**TII Response to Hampstead Residents' CLG Submission (made  
on 21 February 2024)**

TII would like to take the opportunity to sincerely thank Hampstead Residents CLG for their continued involvement in the MetroLink Project, and for Declan Campbell's submission (on behalf of Hampstead Residents CLG) (HR CLG) to the Oral Hearing on 21 February 2024. As agreed with Mr Campbell and the Oral Hearing's Inspector, we committed to providing a written response to HR CLG'S submissions since we could not address these issues within the time allotted by the hearing on 21 February 2024.

ALBERT COLLEGE PARK INTERVENTION SHAFT. PLAN
SCALE 1:400

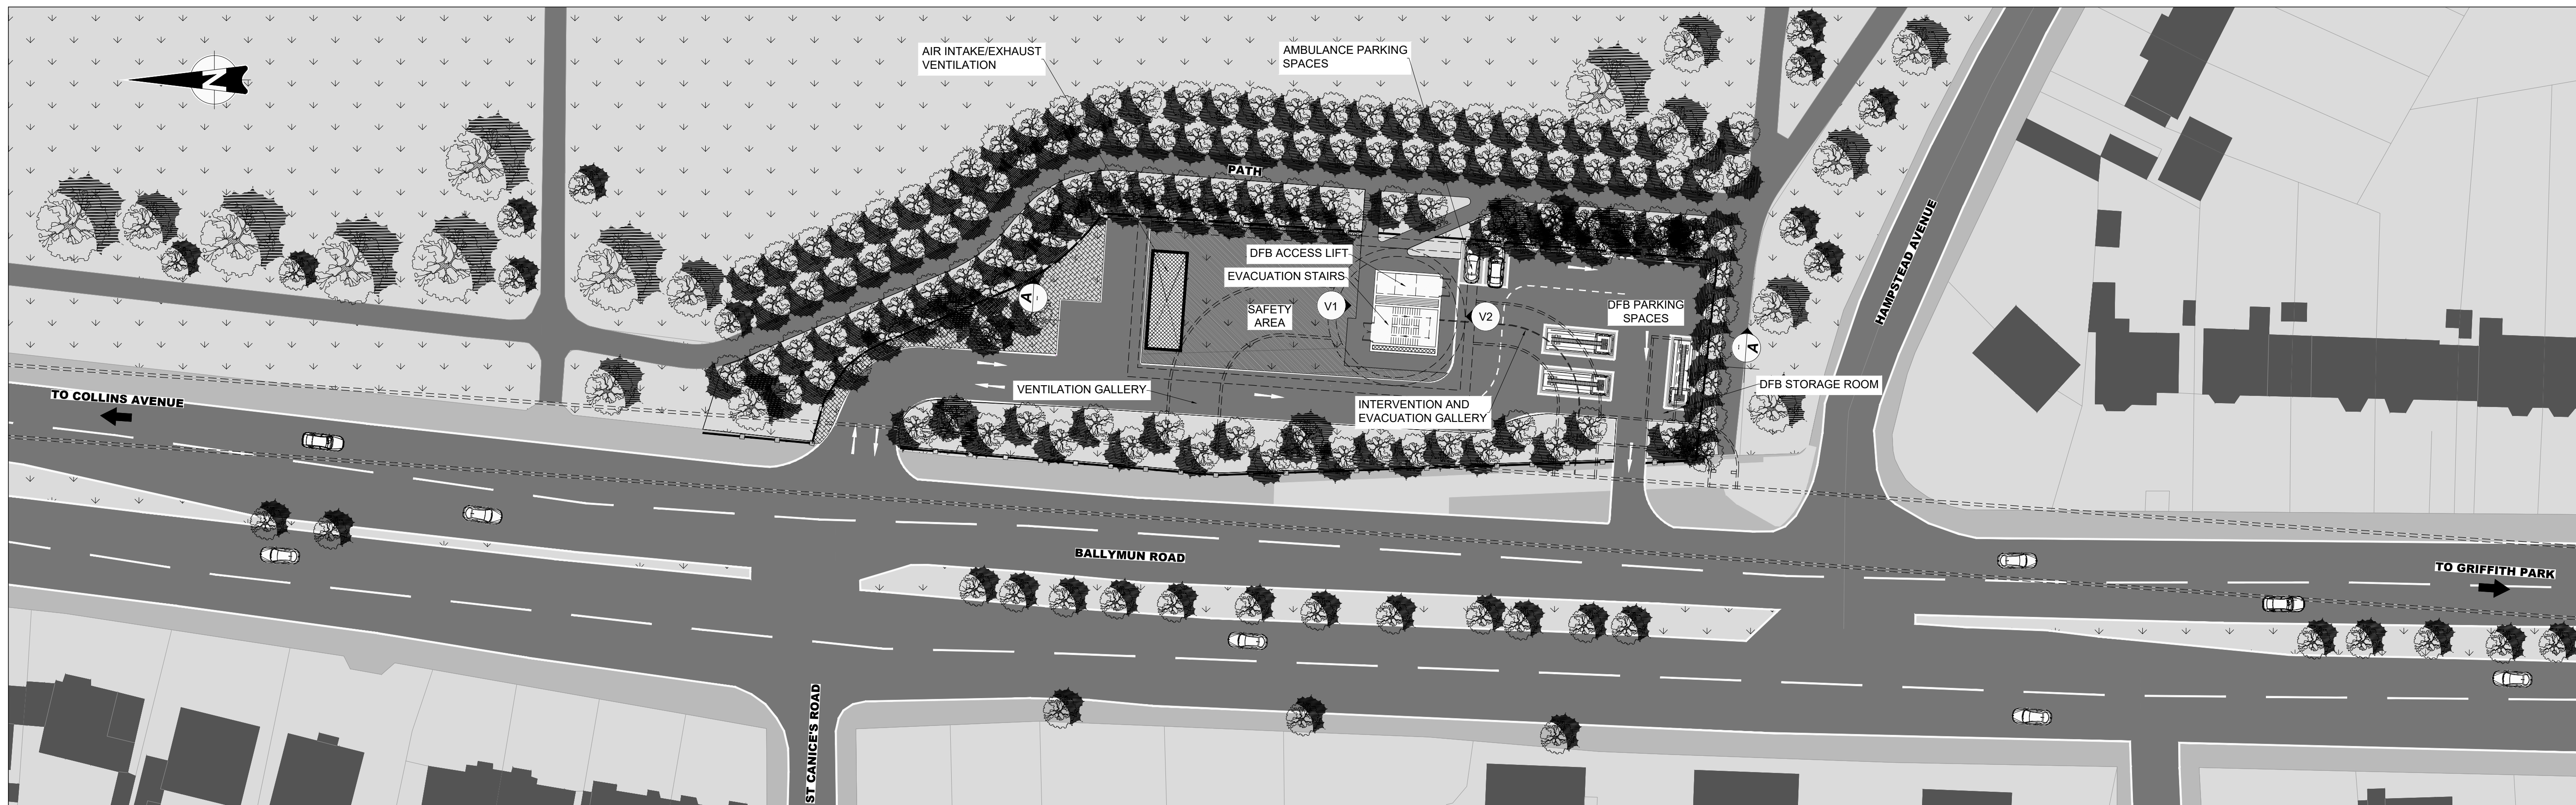
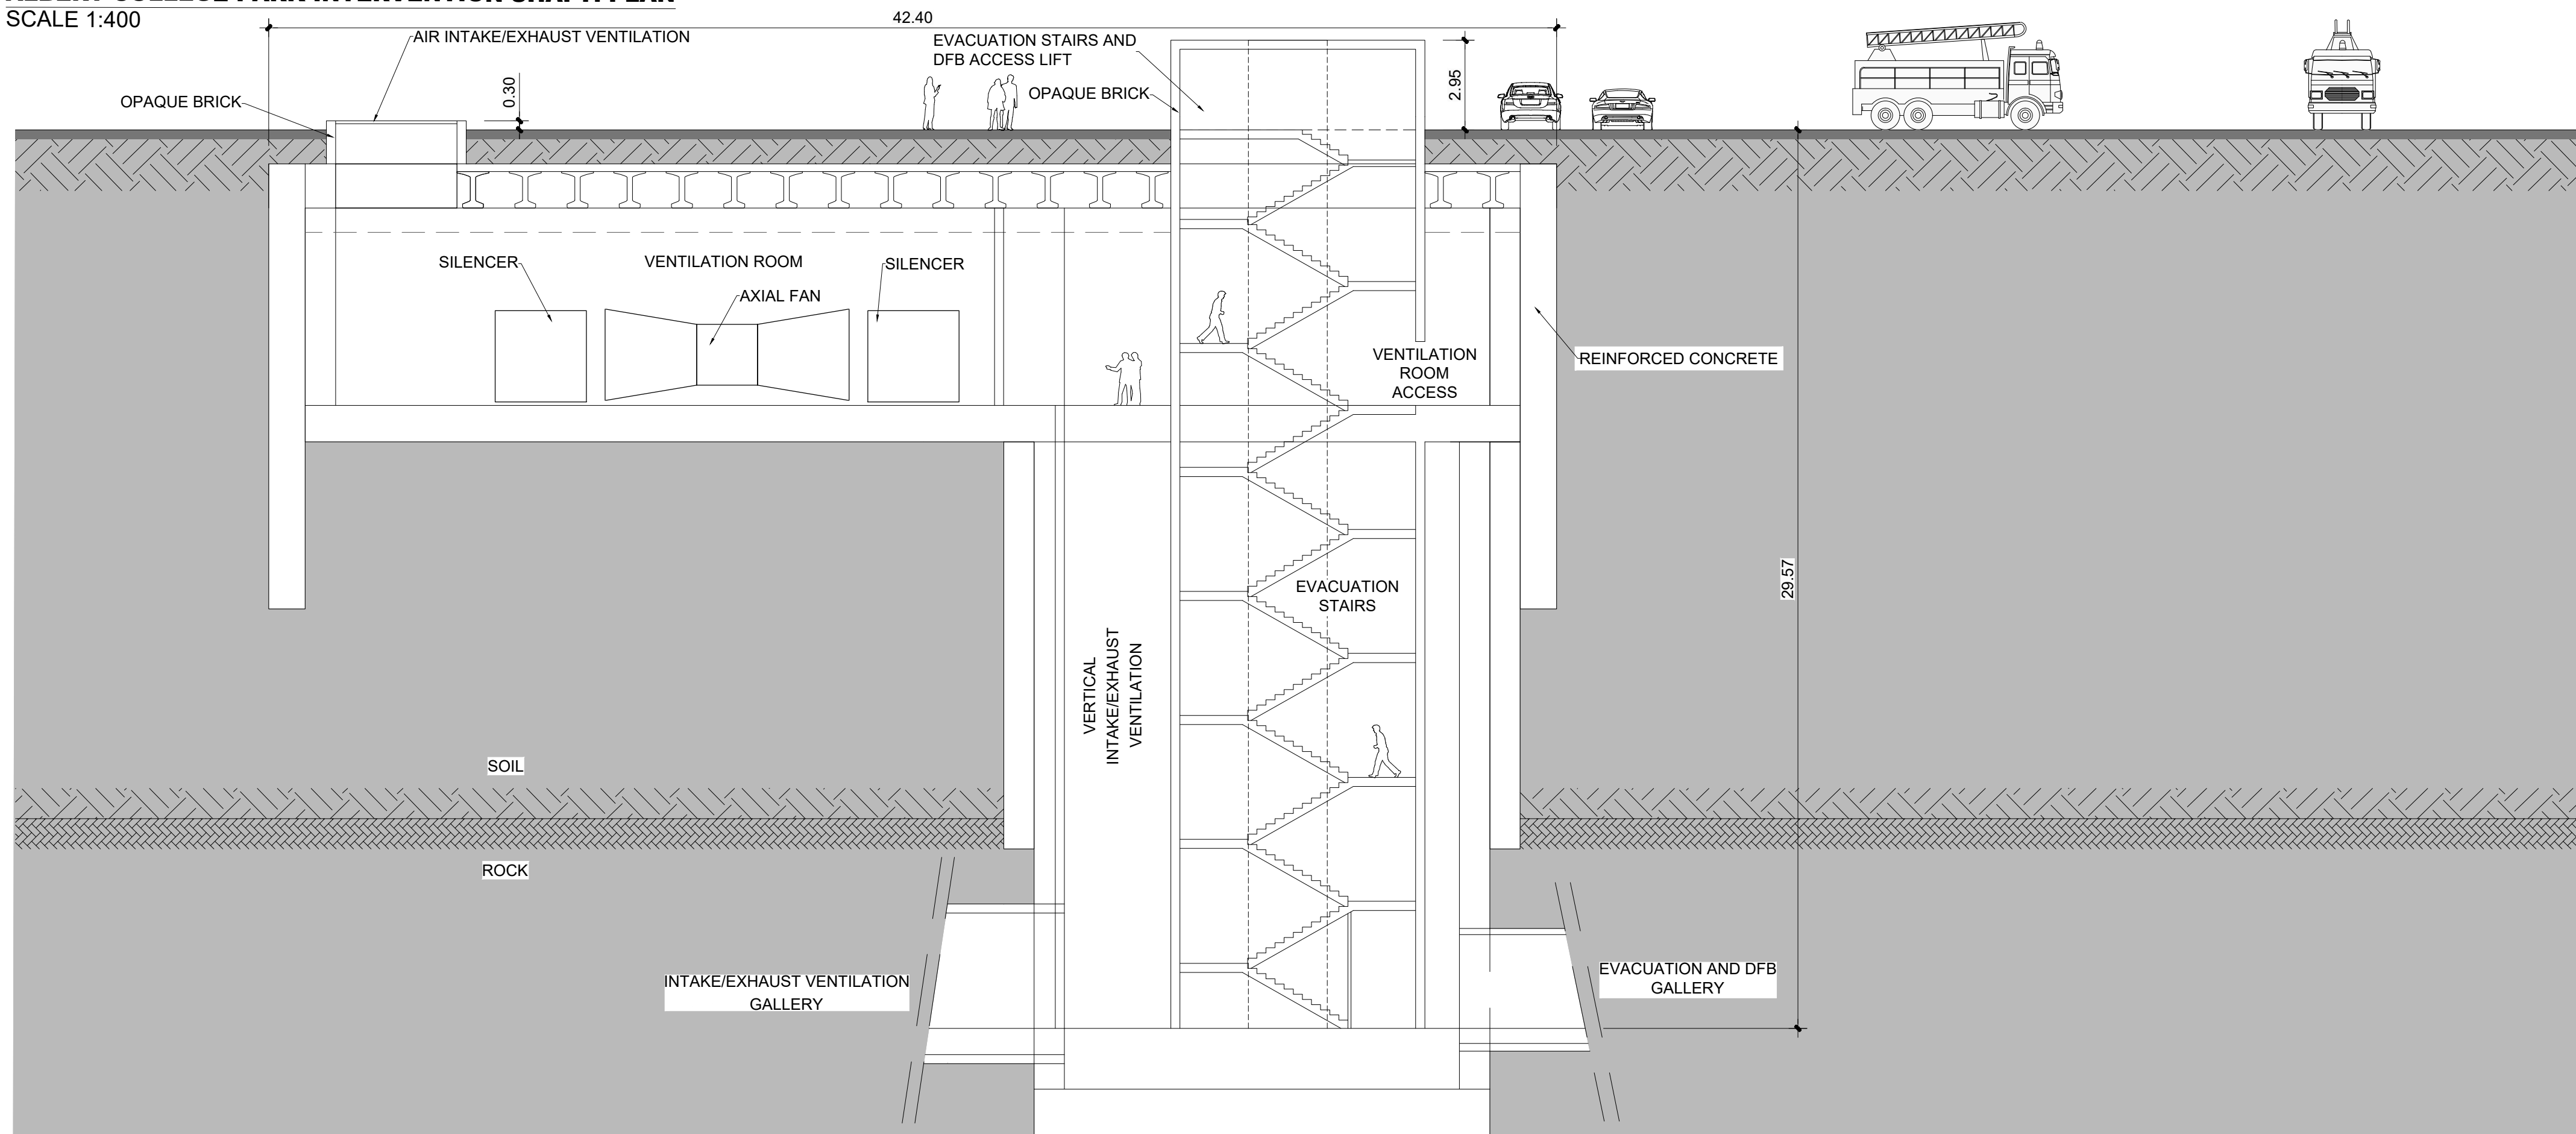
During the public consultation, local residents requested that more information be provided about the shaft so they could properly consider its impact on the surrounding area. The MetroLink team prepared an information

While we believe that the intervention shaft is in the correct location, we are willing to work with the local community to explore additional measures in relation to the appearance and presentation of the shaft including boundary treatment, mature tree planting, materials, and finishes.

Regarding specific concerns relating to 'potential anti-social activities that may occur in or around a MetroLink structure that may be placed in Albert College Park', we confirm that the Albert College Park Shaft compound will have appropriate secure fencing around the compound with secure access gates.

We acknowledge the concerns of the local residents in relation to the potential negative noise vibration and air quality-ingress and egress at ventilation fan locations. In that regard, we would like to provide more details on the operational ventilation systems provided for Albert College Park Shaft, and their inspection and maintenance, which we hope will provide further re-assurance to HR CLG.

Regarding large volumes of warm air from the MetroLink tunnel forced out of the vent grilles in cold weather, it should be noted that all the ventilation systems in Albert College Park Shaft will only be used in the event of an emergency or infrequent congestion or service incident. Therefore, there is no inlet or outlet air movement during normal operation that could create 'clouding' or 'fog' plumes.

The fencing and gates will be a mesh weld fence (of the type shown in EIAR Chapter 4, Section 4.12.9.3), which is transparent. On the park side of the compound, a new path is provided to link the existing footpaths. We are therefore confident that the proposed compound does not lend itself to an environment that would pose an increase in anti-social activities. The Albert College Park Intervention Shaft will be monitored 24/7 by CCTV and staff at the Operational Control Centre (OCC).

The only system in ACP Shaft generating outdoor Noise/Vibration or Dust is the Tunnel Ventilation System (TVS). It comprises three reversible axial fans situated in parallel, one of them acting as a contingency stand-by fan. TVS system is dimensioned for emergency cases to allow for moving and exhausting smoke, creating safe paths for evacuation. In normal operation, TVS is not normally used since the piston effect in the tunnel is sufficient to maintain the temperature and ventilation conditions in service.

In summary, Albert College Park Intervention Shaft ventilation equipment is only used in the event of an emergency or infrequent congestion or service incident at low speeds and low noise levels. Reflecting the safety critical nature of the facility and associated equipment, the inspection and maintenance programme is frequent, and includes checking operational performance and noise and vibration values.

Rarely, in case of overheating in the tunnel, would it be necessary to partially activate one of the three Albert College Shaft fans to maintain the ventilation and temperature conditions. This infrequent event would last only a few minutes and it will involve larger volumes of hot air, as it only activates partially one of the three jet fans.

During a fire emergency, only in the very unlikely event of a stationary train on fire in the tunnel between Collins St. and Griffith Park St., which cannot be moved to the next station, will the Tunnel Ventilation System (TVS) in Albert College Park be activated. If this happens, the ventilation will draw the smoke in one direction and evacuation should proceed in the opposite direction. Albert College Park Shaft grilles would evacuate the smoke of the fire event.
